Re: Bango Wind Farm (SSD 6686)

Thank you for the opportunity to comment on the proposal by CWP Renewables on the Bango Wind Farm.

FIGURE 10.13: THREATENED SPECIES RECORDED ACROSS THE STUDY AREA - MT BUFFALO CLUSTER

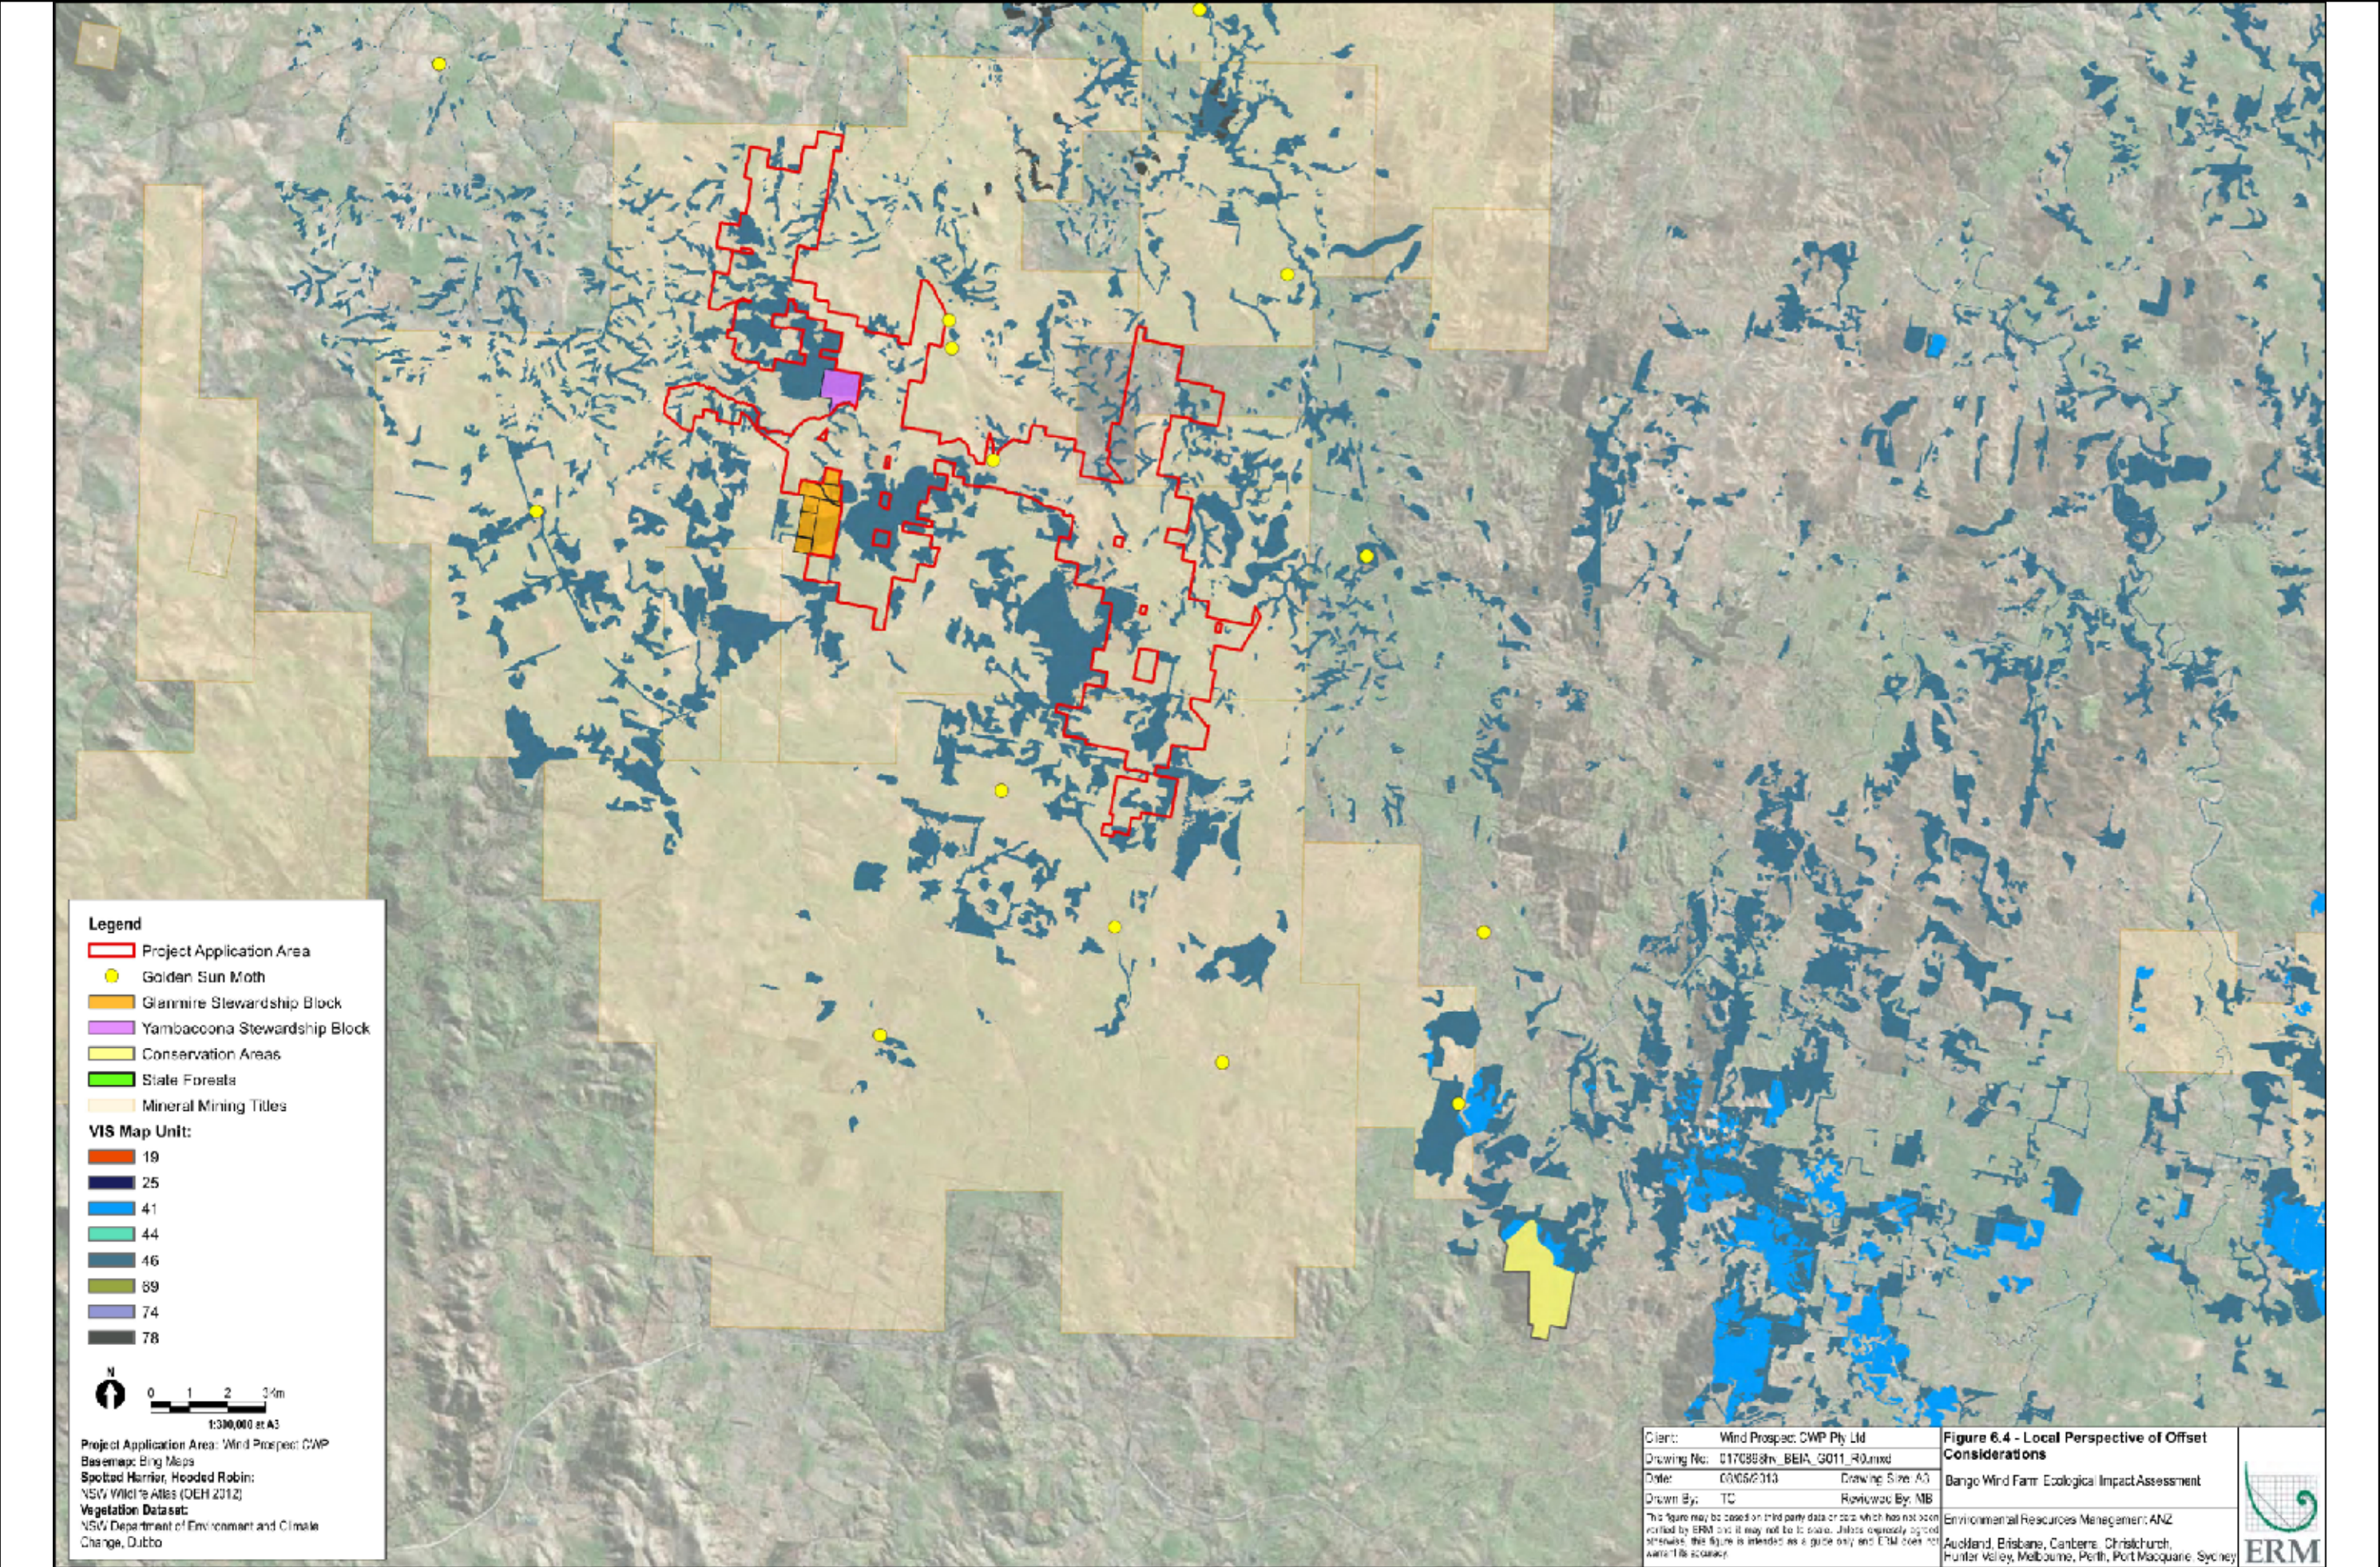
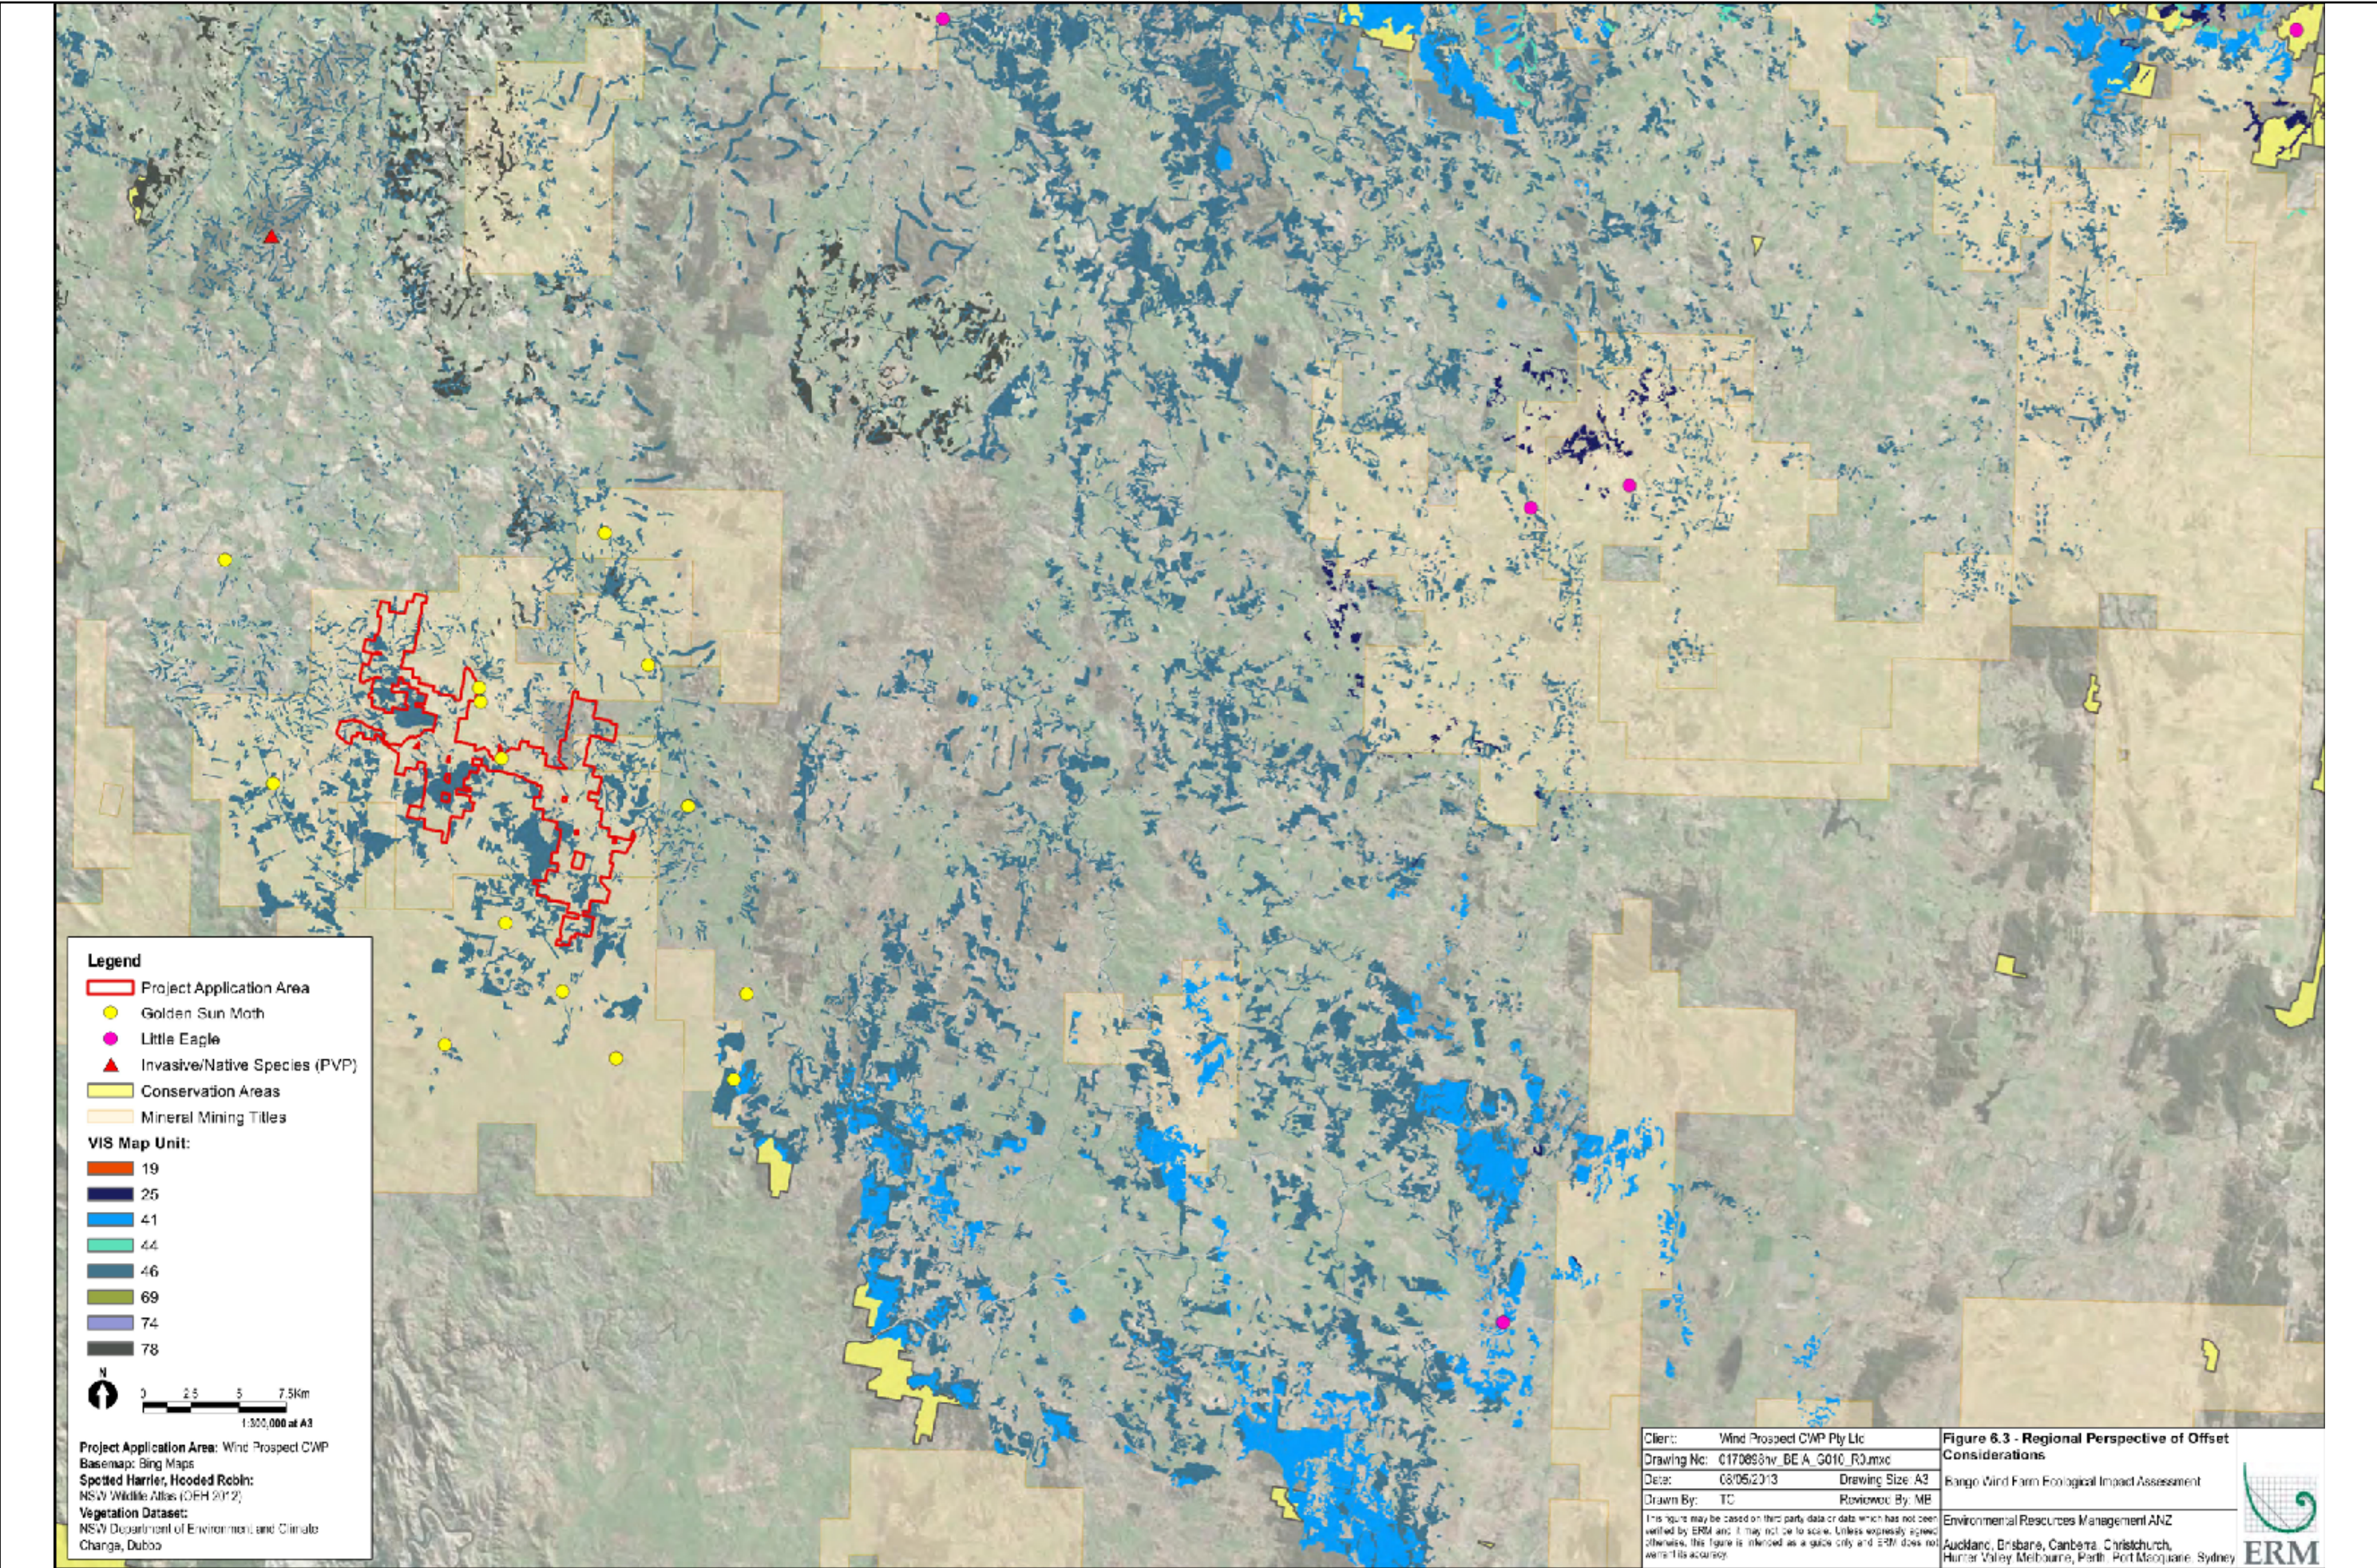
- Page 207 lists the large number of 'Fauna Groups' in the proposal area. Will this be taken into consideration?
- Page 212, figures 10.11, 10.12, and 10.13 Threatened species tables. These are dated 3/5/2013. If this is the date of surveys they would not have found many Superb Parrots around at this time of the year and needs clarifying. And again surely studies more recent than 2013 could have been found to more accurately indicate the current story.
